Our Case Number: ABP-314724-22

Re: Railway (Metrolink - Estuary to Charlemont via Dublin Airport) Order [2022]
Metrolink. Estuary through Swords, Dublin Airport, Ballymun, Glasnevin and City Centre to
Charlemont, Co. Dublin

**GADRA Submission to Second Statutory Public Consultation on Metrolink
NA29N.314724**

Slide 1 – Alternative Station Location at Albert College Park

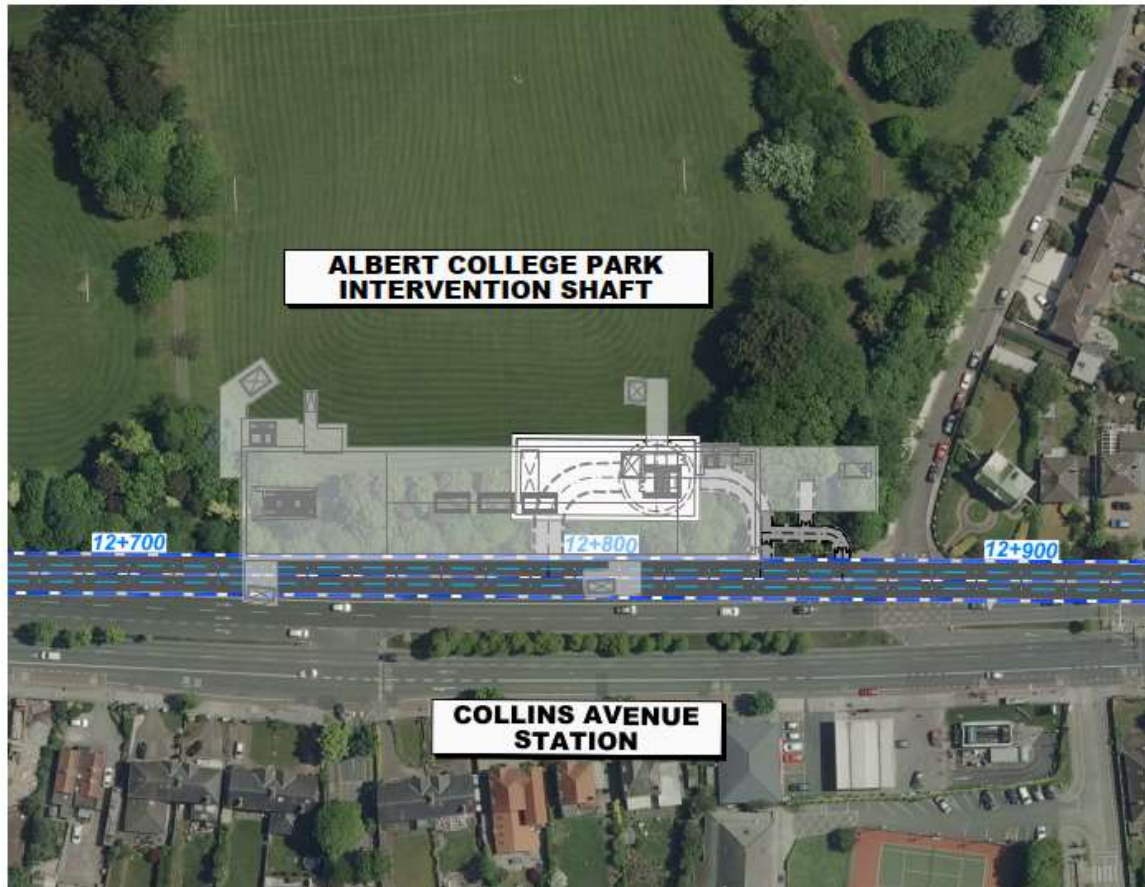
We would like to draw the attention of the Inspectors to *DAY4 ACP Comparison of Shaft V Station* which fails to include the planned fenced compound in size, nor does it indicate that the shaft is above ground and station below ground.
